Application Ref: H16-1096-23

Proposal: **Proposed Anaerobic Digester Plant**

Location: **Land between A16 and Rangell Gate, Spalding**

Updated interim response

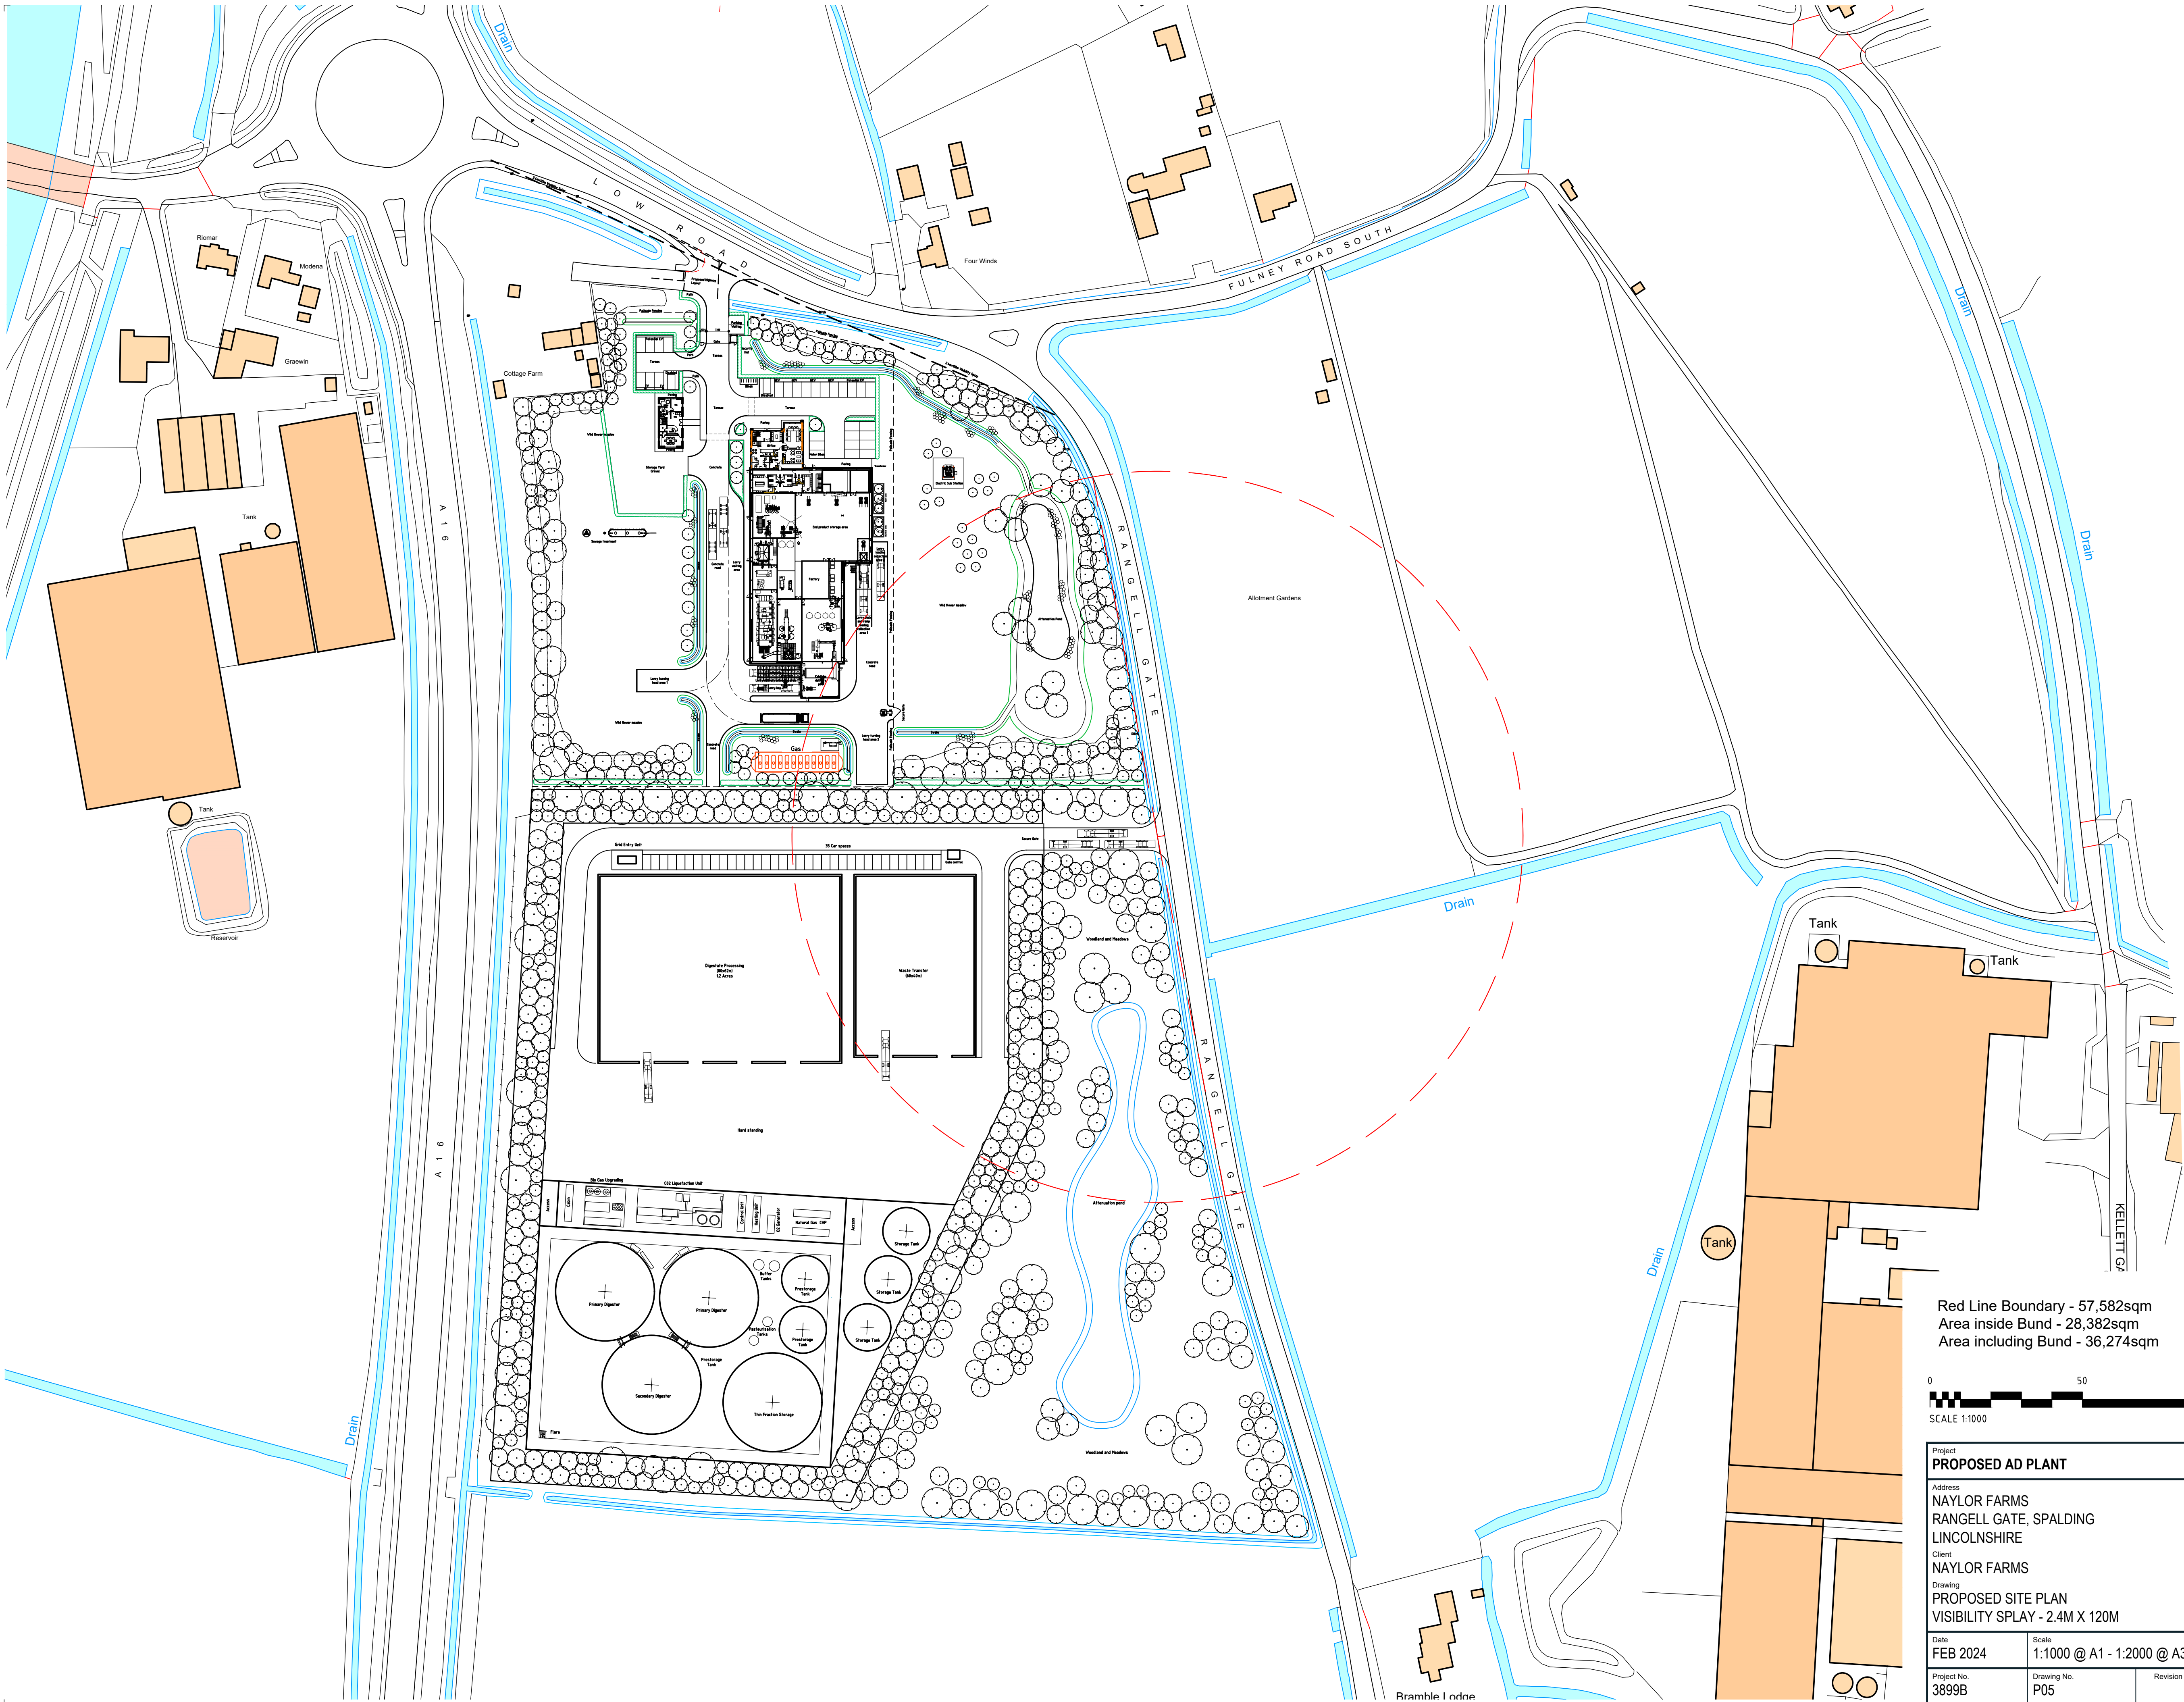
We have concerns with accessing this site from the A16 - access should be from the existing site entrance off the B1165.
